OFFICIAL NOTIFICATION OF DECISION

Project# PR-2020-003626
Application#
SD-2020-00130 PRELIMINARY/FINAL PLAT
VA-2020-00360 DPM WAIVER

For all or a portion of: **7A & 7B, VAN CLEAVE ACRES** zoned R-A, located at **1540 VAN CLEAVE NW between SAN ISIDRO ST and GRIEGOS LATERAL**, containing approximately 0.8233 acre(s). (G-13)

SIDEWALK EXHIBIT  
(PR-003626)

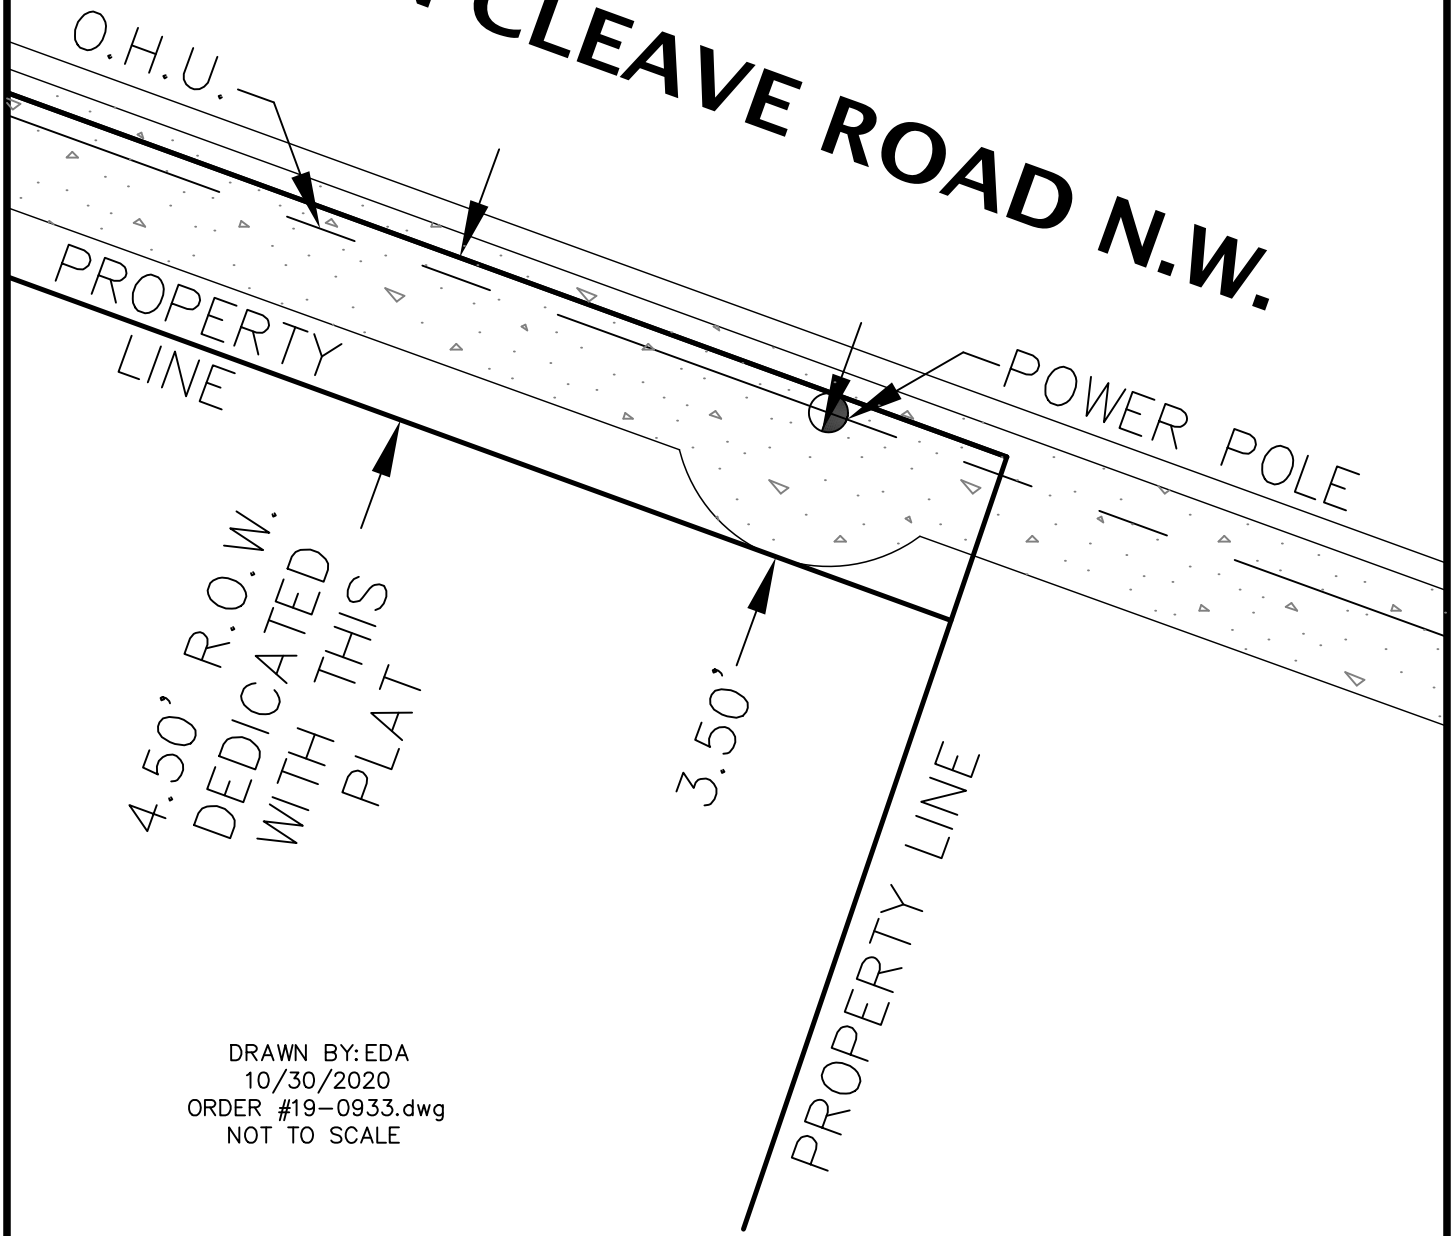
1. Final sign-off is delegated to Transportation for a sidewalk bulb-out around a power pole in front of the property.
2. Final sign-off is delegated to Planning for the utility company signatures, an AMAFCA signature, and the AGIS DXF file.
3. The applicant will obtain final sign off from Planning by January 4, 2021 or the case may be scheduled for the next DRB hearing and could be denied per the DRB Rules of Procedure.

1. The applicant proposes a waiver to the IDO/DPM standard(s) for the 4-foot minimum width for a sidewalk to permit the existing 3.5-foot wide sidewalk between San Isidro Street and the Griegos Lateral. The request is justified because the Van Cleave Acres subdivision was platted in 1933, and sidewalks may have been constructed shortly thereafter, prior to the enactment of zoning requirements in the City.
2. The applicant provided the required notice as outlined in the IDO Table 6-1-1.

PLAT OF  
 LOTS 7-A-1 & 7-B-1, BLOCK 2  
 VAN CLEAVE ACRES

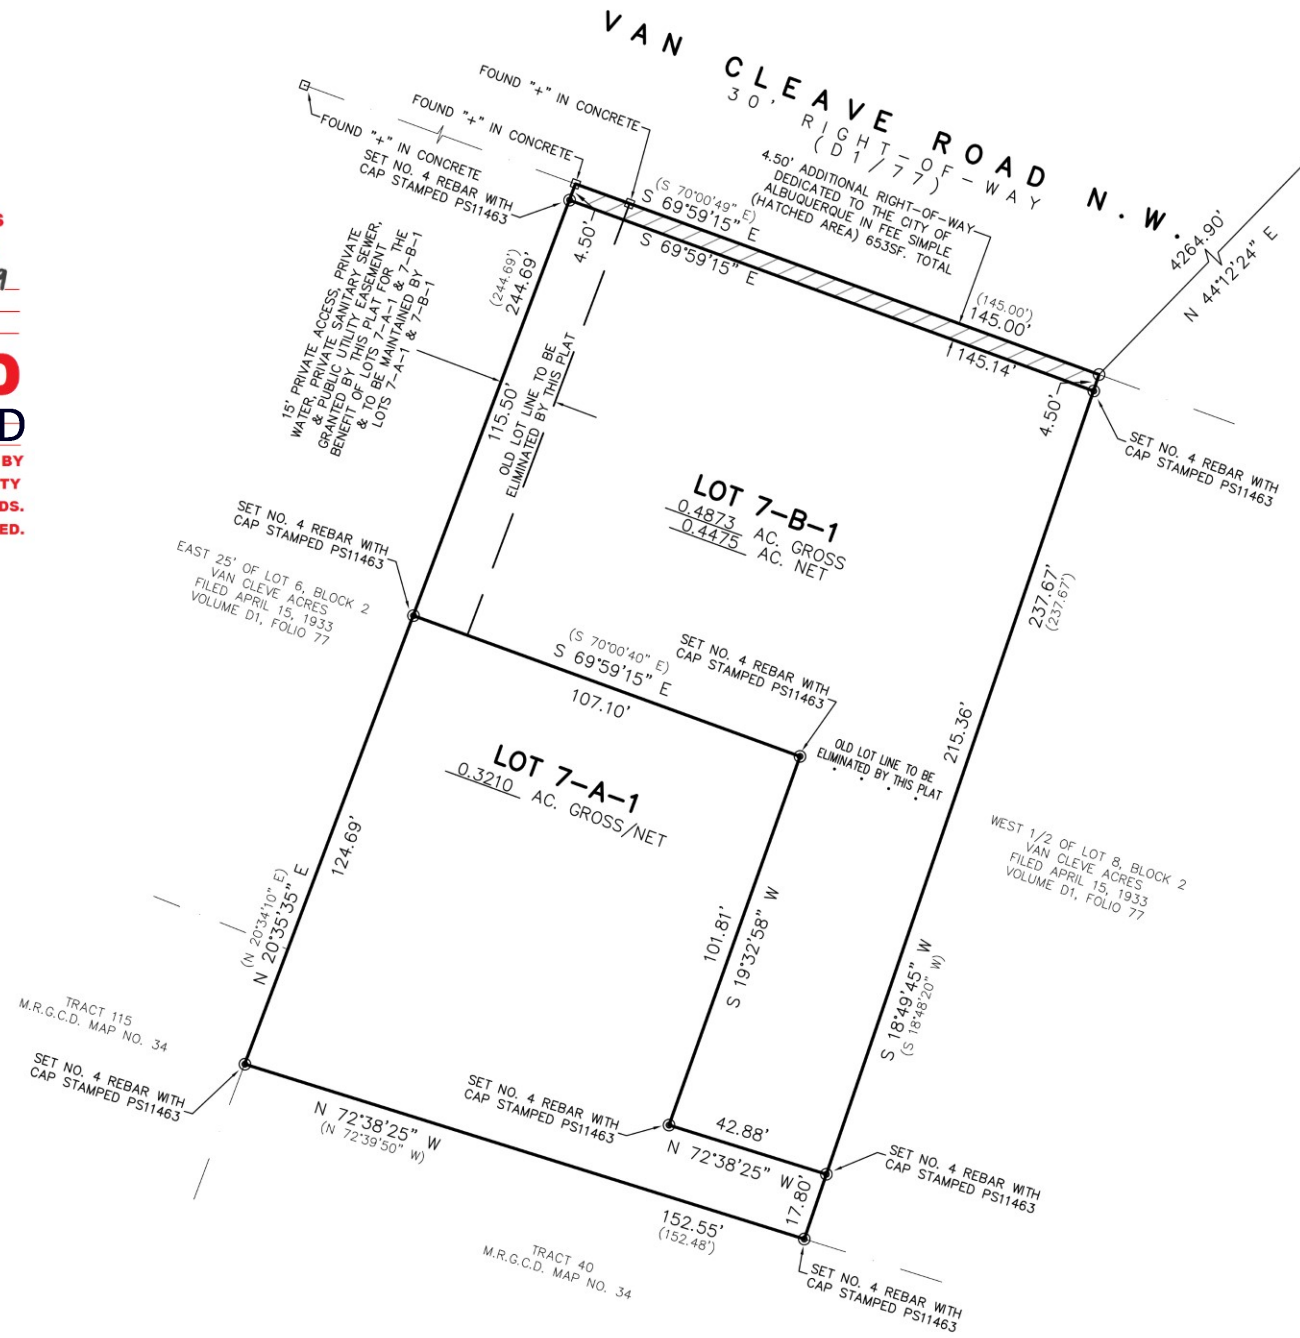
1. This Preliminary/Final adjusts the lot lines between two existing lots consisting of a total of 0.8233 acres in size (Lot 7-B-1, 0.5548 acres in size, and Lot 7-A-1, 0.2685 acres in size).
2. The property is zoned R-A. Future development must be consistent with the underlying zone district.
3. The applicant provided the required notice as outlined in the IDO Table 6-1-1.
